## Review Letter

**DATE:** May 4, 2022

**FROM:** Jonathan Moore, PE, District Engineer

**RE:** The Cottages at Mesa Ridge – Construction Drawings and Final Plat dated April 5, 2022

SHEET **SAN** 21

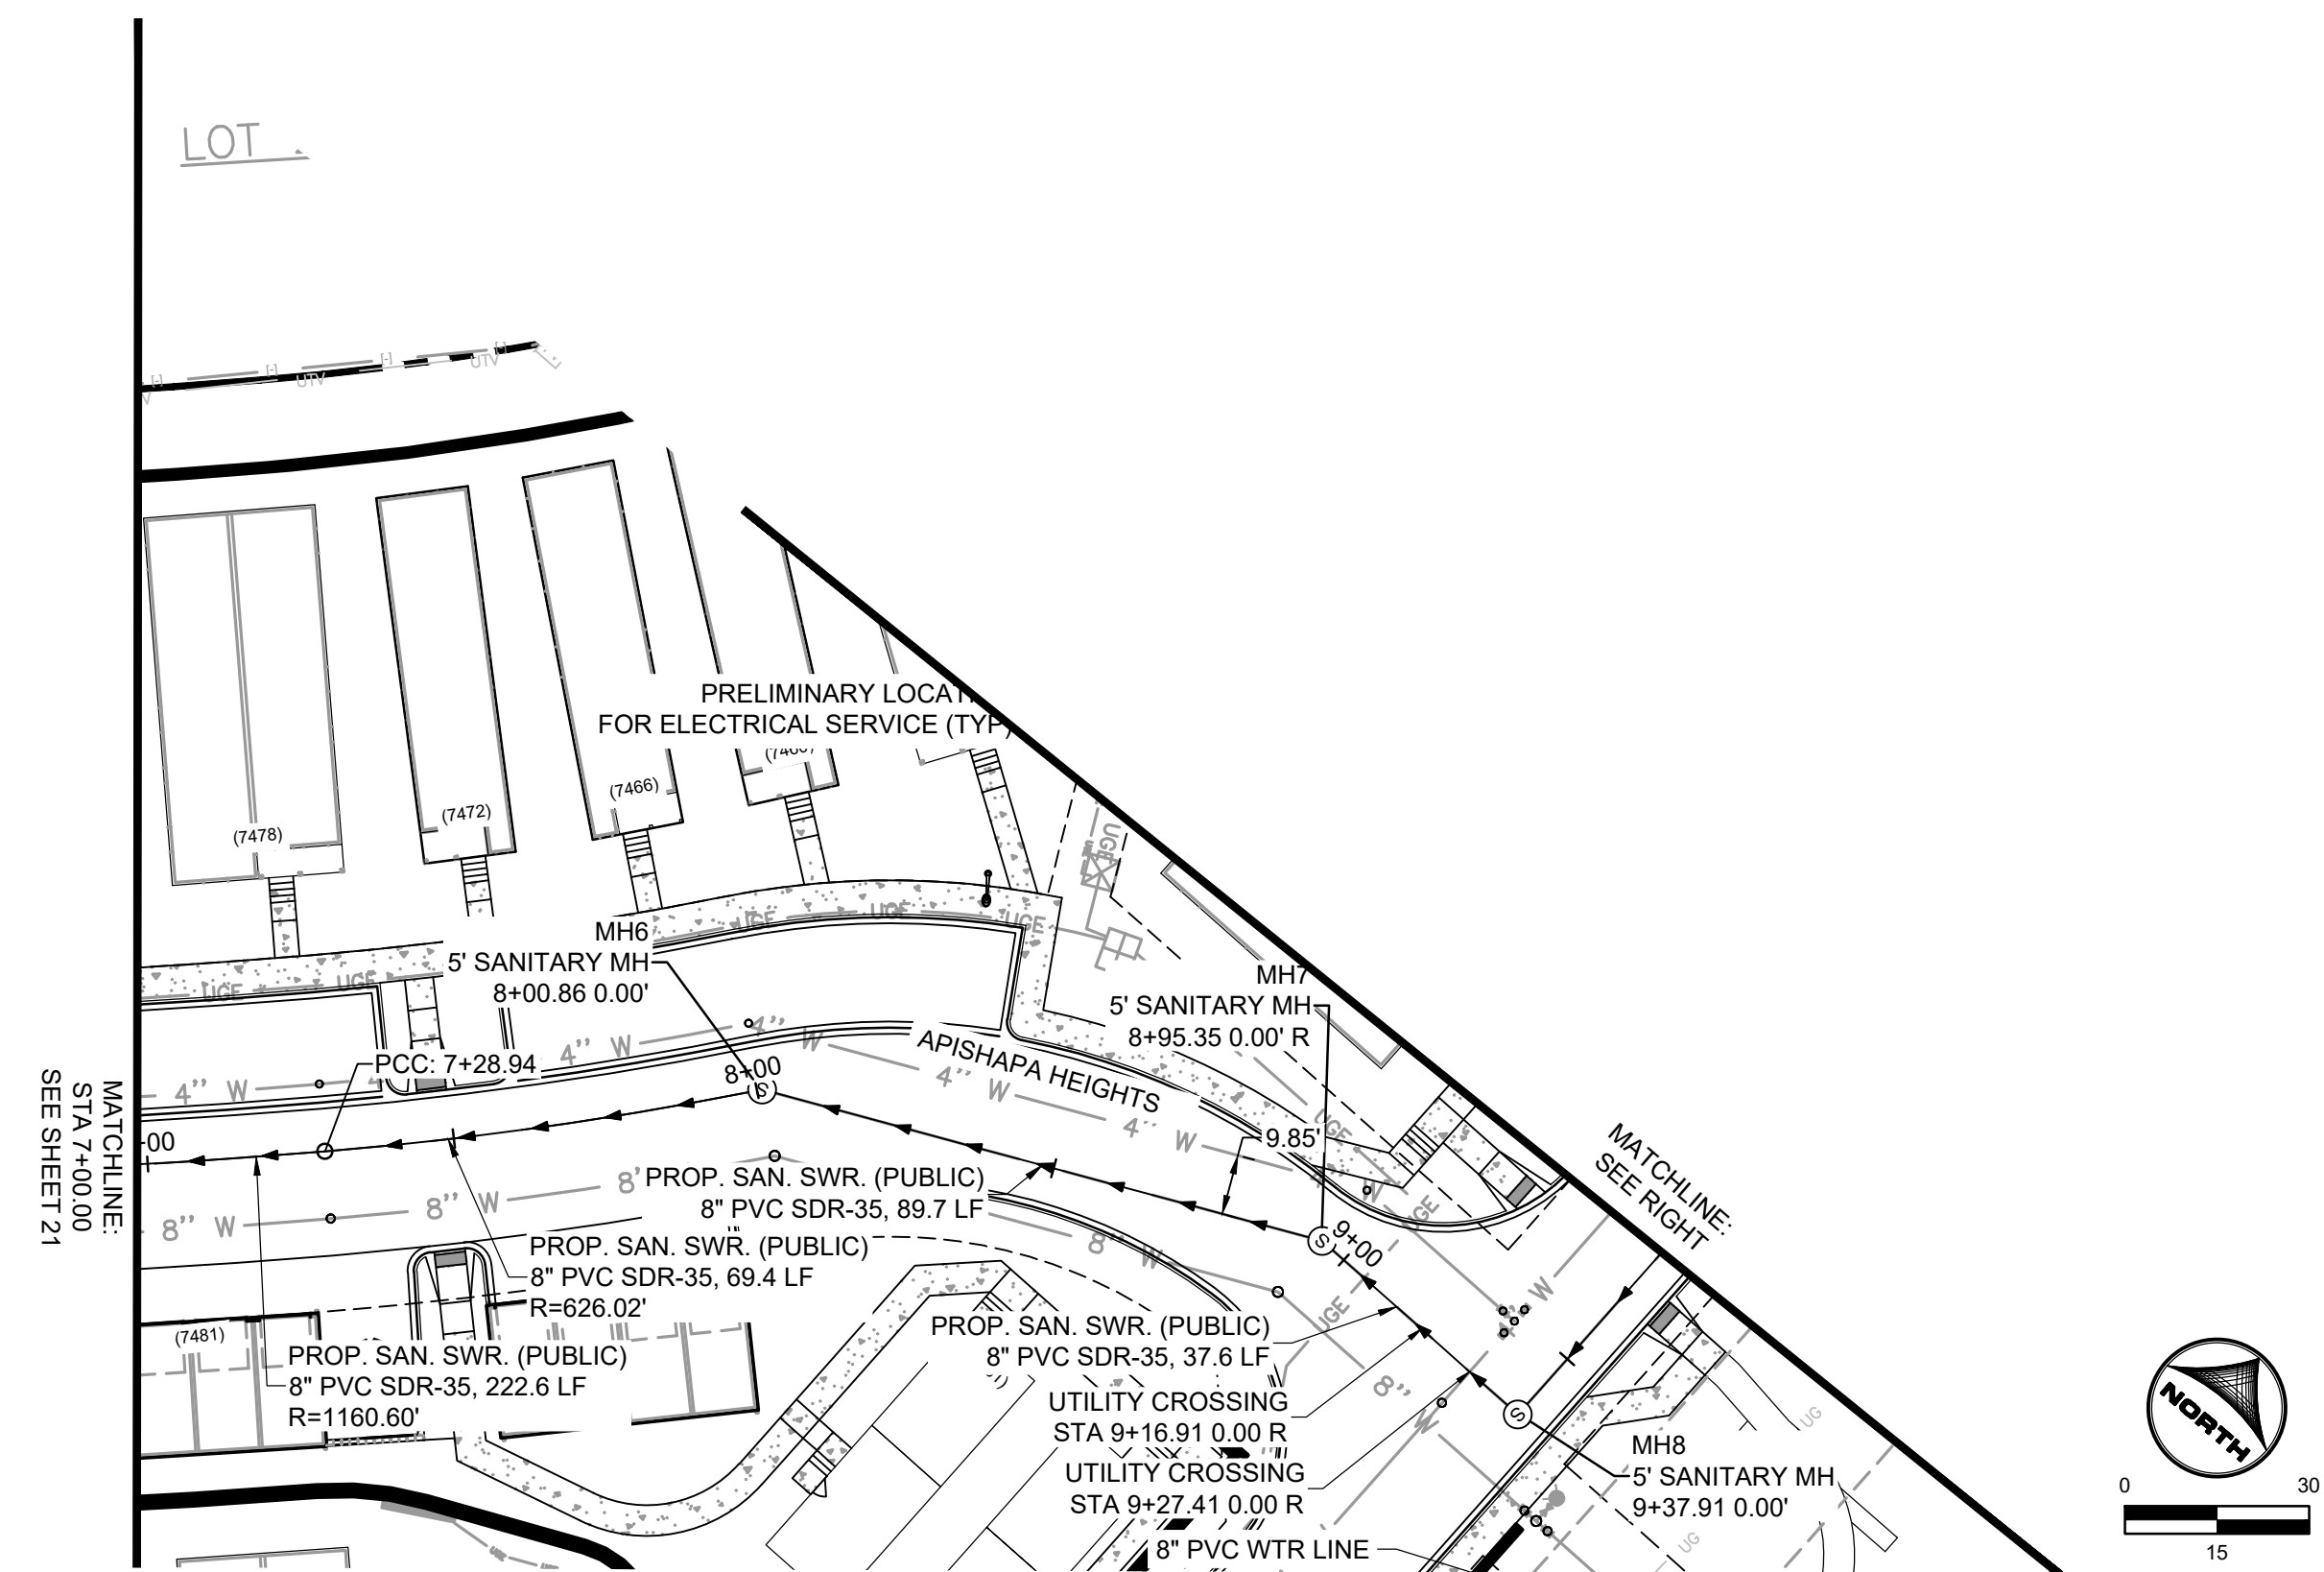
1. Add FSD signature block.
2. Create a plan and profile sheet with the plan on top and the profile on the bottom of the page, see FSD design regulations, Part B.
3. Label the sanitary sewer in the plan view as Prop. San. Swr. (Public) 8" PVC SDR-35.
4. Add Prop. 8" PVC SDR-35, xxxx LF at x.xx% (Public) to the pipe label in profile view.
5. Show the san. swr. radius in plan view, a minimum of 270' is allowed, add additional manholes as needed.
6. Show all utility crossings in profile, a minimum of 18" of vertical separation is required. Label all vertical separations in profile view.
7. Profile vertical lines should be spaced per the vertical scale. FSD prefers a horizontal scale of 30 and a vertical scale of 5.
8. All san. swr. manholes must be a minimum of 5' in diameter.

SHEET  
**STM**  
 8

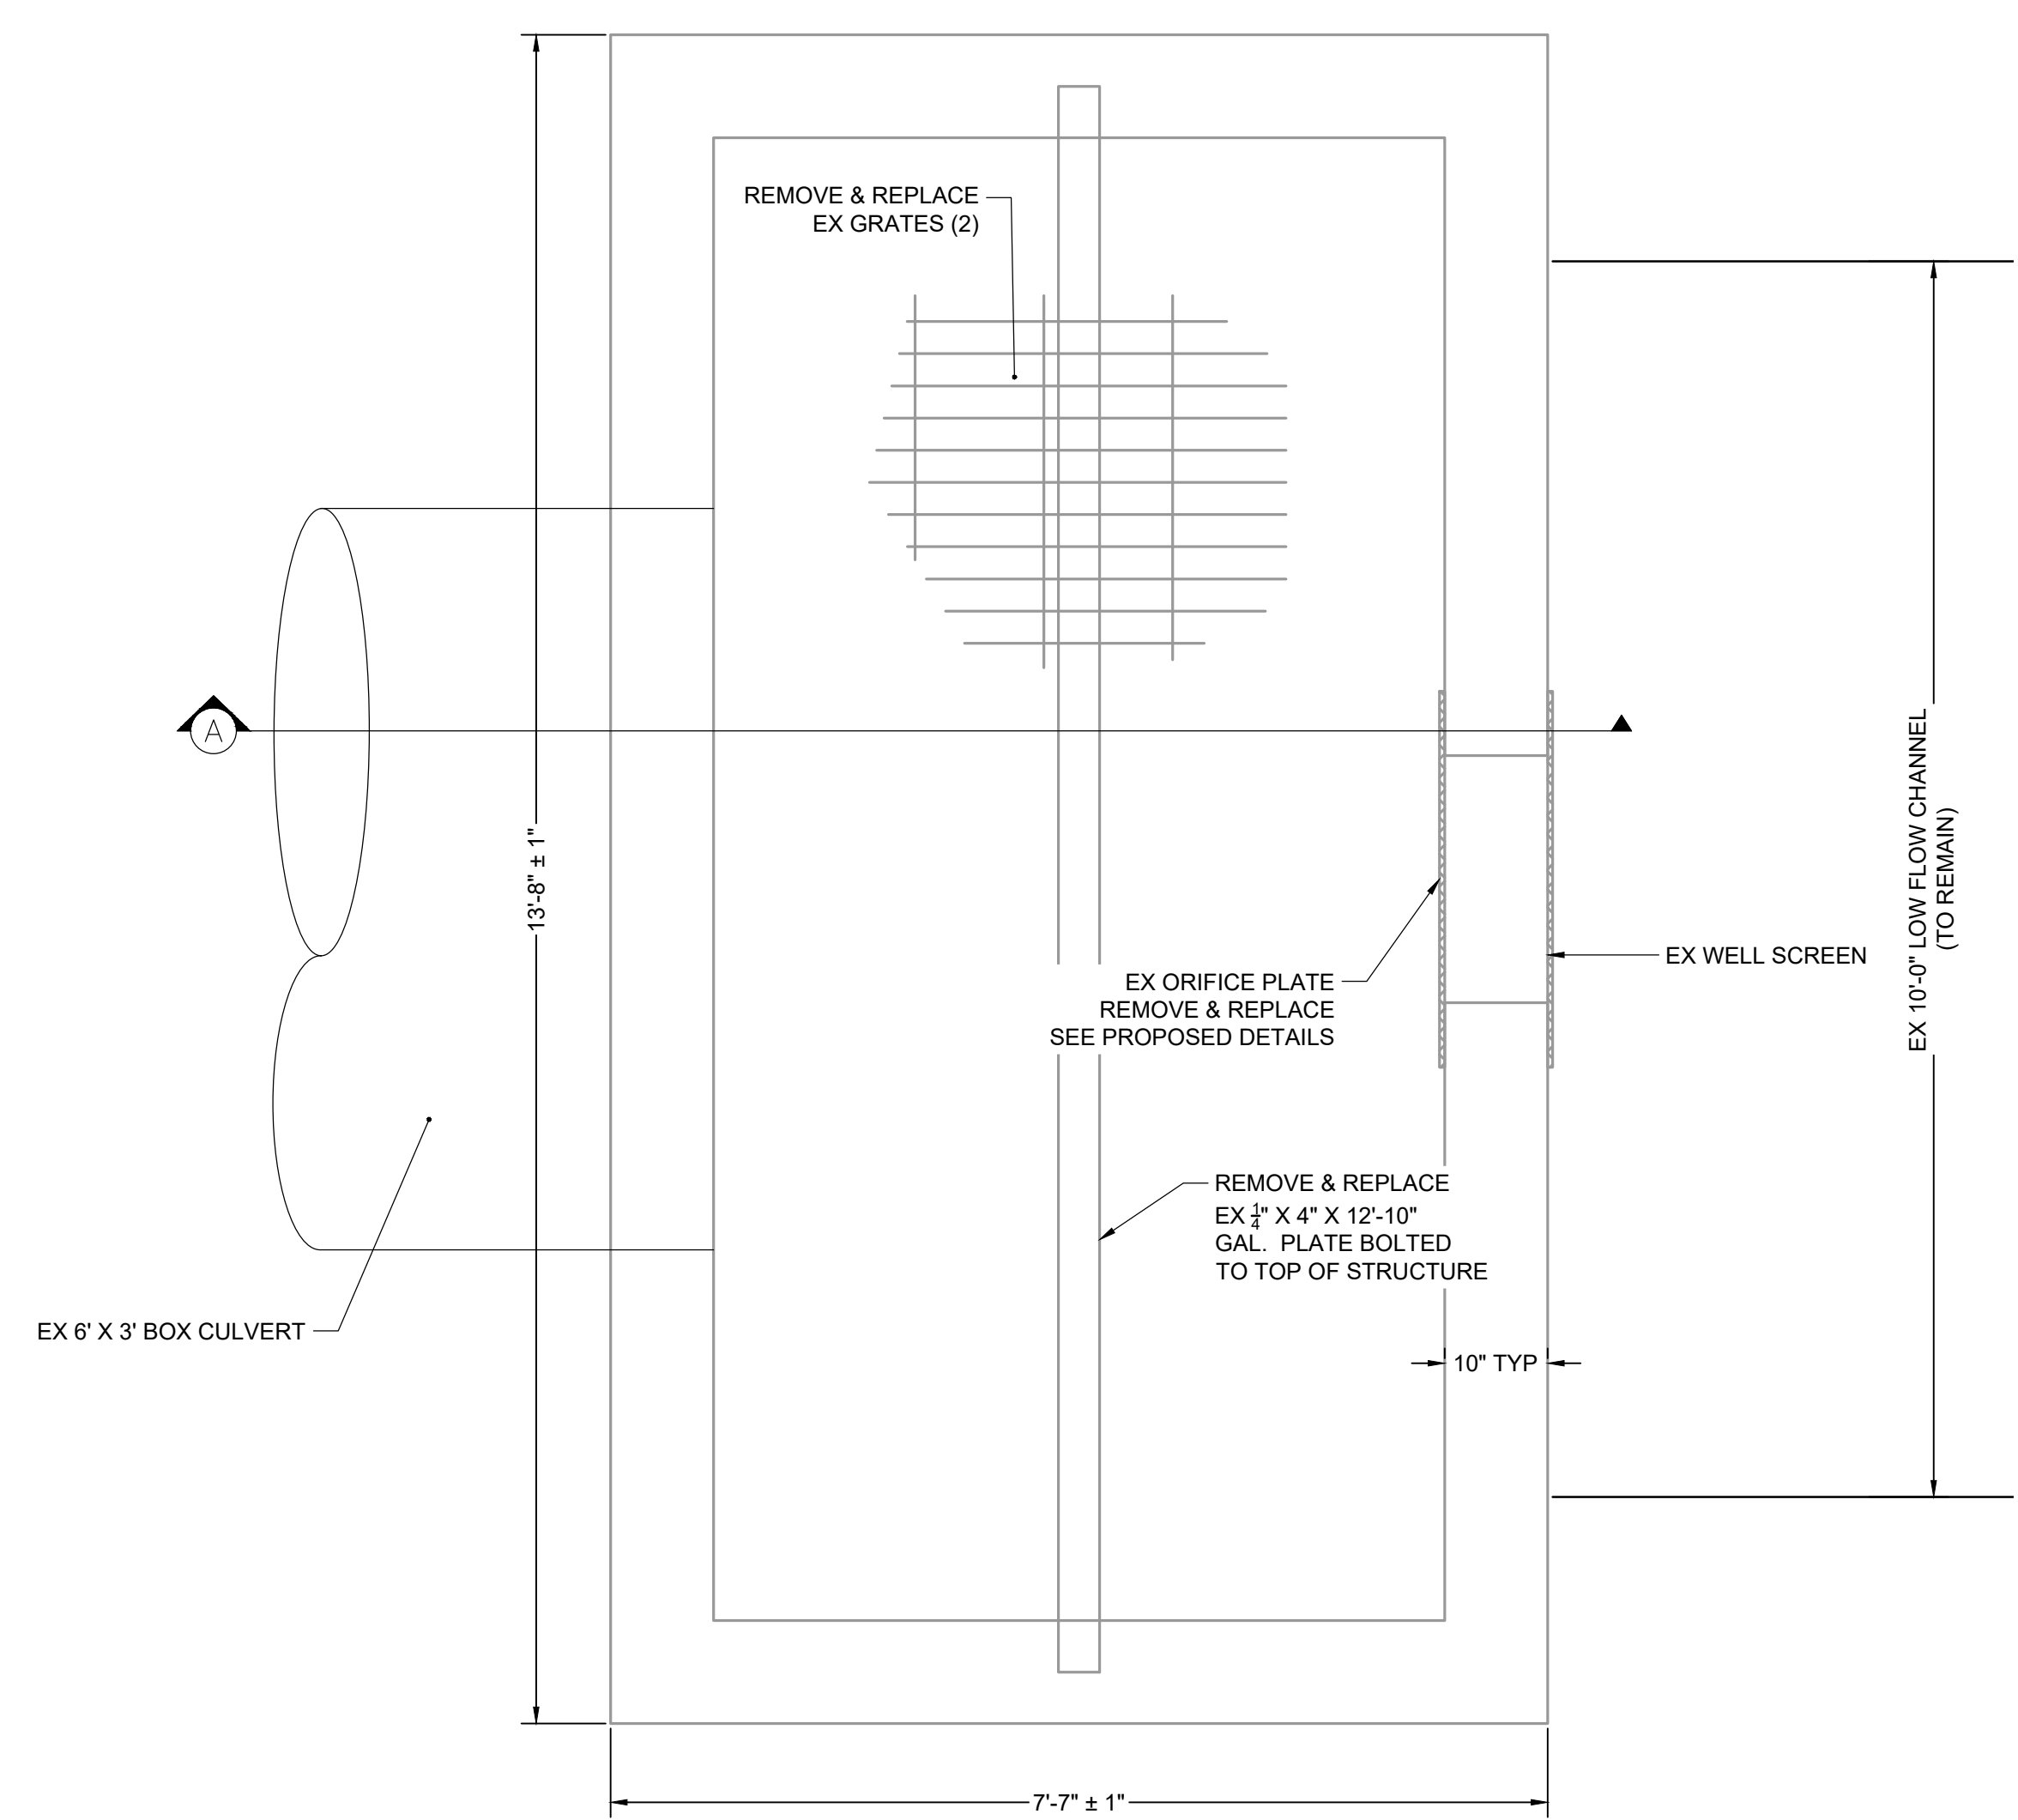
1. A minimum of 18" vertical separation between san. swr. and storm is required, revised design.
